City of Albuquerque
Planning Department
Inter-Office Memorandum

SUBJECT: Project # 1008787

On June 9, 2011, the Environmental Planning Commission approved Project #1008787 11EPC 40032/40030/40036, a amendment to a sector development plan zone map from C-2 to SU-1 for Fire Station, a site development plan for building permit, and a site development plan for subdivision for the southerly 337' portion of Tract C8, Town of Atrisco Grant Airport Unit, a portion of the west 1/2 of Lot 1, Tract C, Lavaland Addition, and a portion of Lot 4, Tract C, Lavaland Addition, located on Central Avenue NW, between 57th Street NW and 58th Street NW, containing approximately 2.0 acres.

City Project No. **8006.00** Zone Map No. **K-11-Z** DWG. **AS-101** Sheet **3** Of **13**

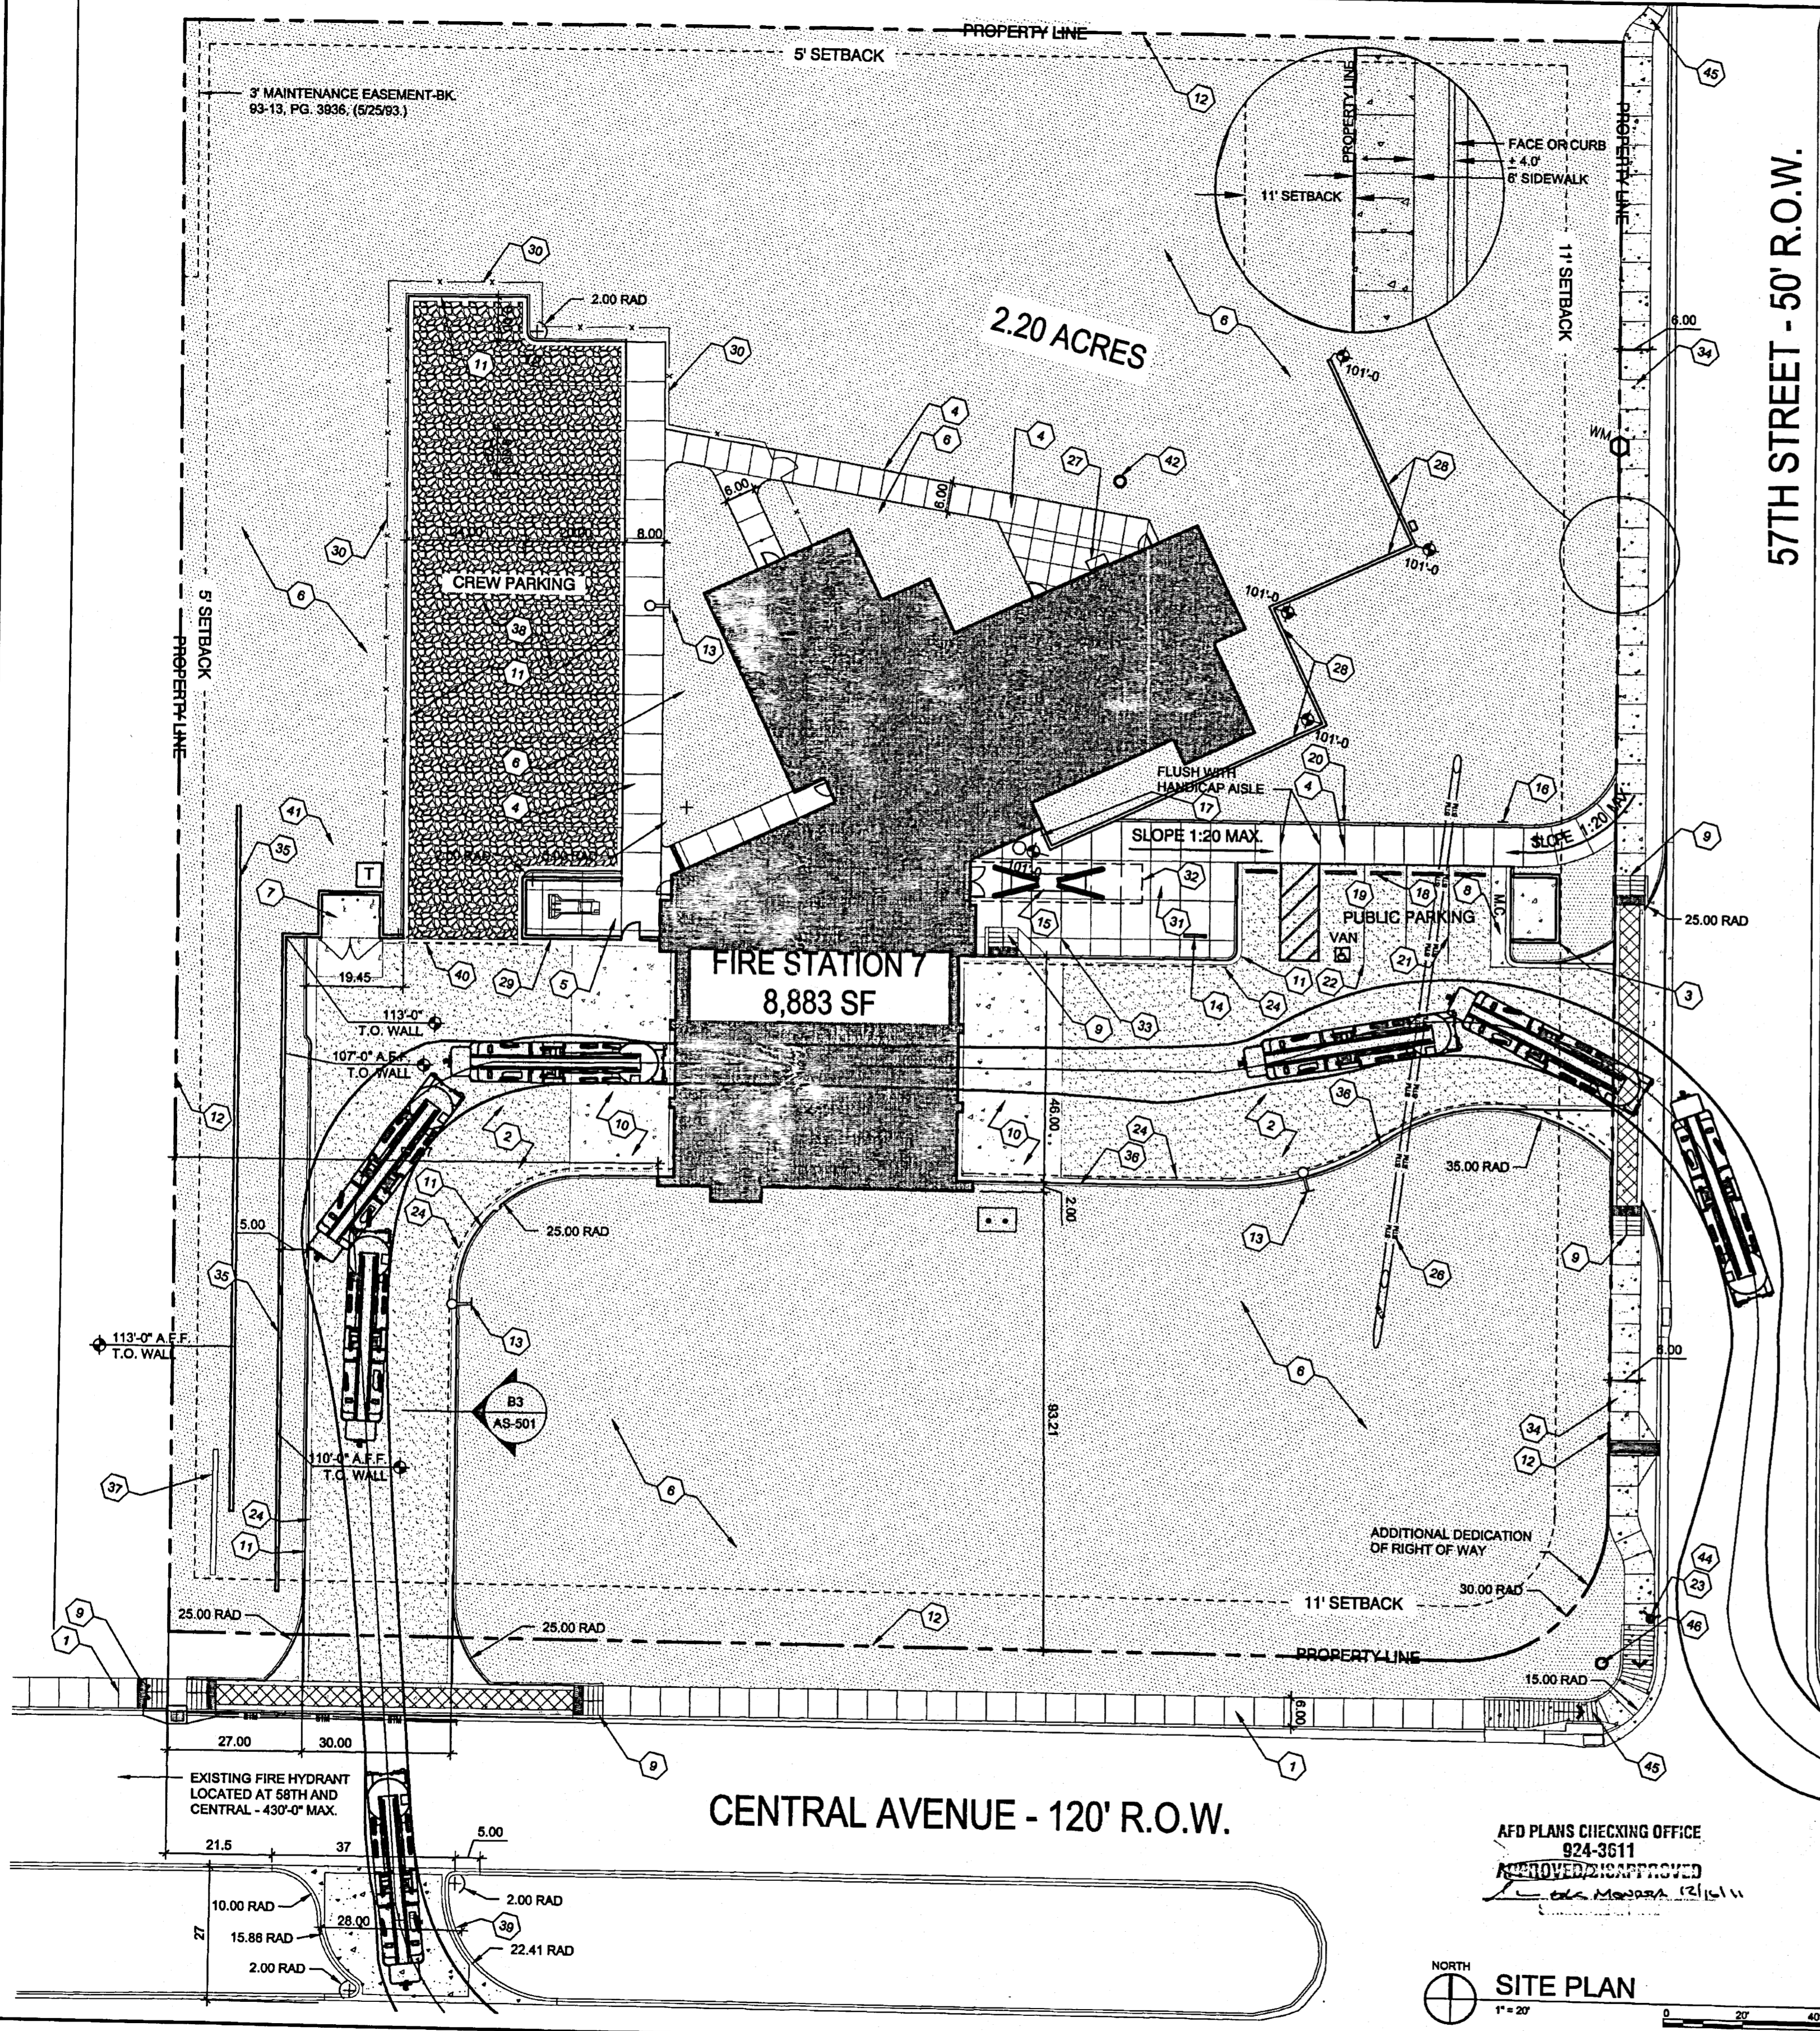
4. As a result of the retaining wall being taller than 4 feet, it shall only be allowed by terracing at a 3:1 slope (per Site Design standard #9 in the WR66SDP).

The applicant states in the letter accompanying the submittal that "Two 4'-0" high retaining walls will terrace the slope at a 3:1 slope have been added to the design in lieu of the 7'-0" high retaining wall." However, the retaining wall is not identified as a 4'-0" wall on the site plan or the site plan details. The retaining wall needs to be identified as a 4'-0" wall on the site plan and the site plan details.
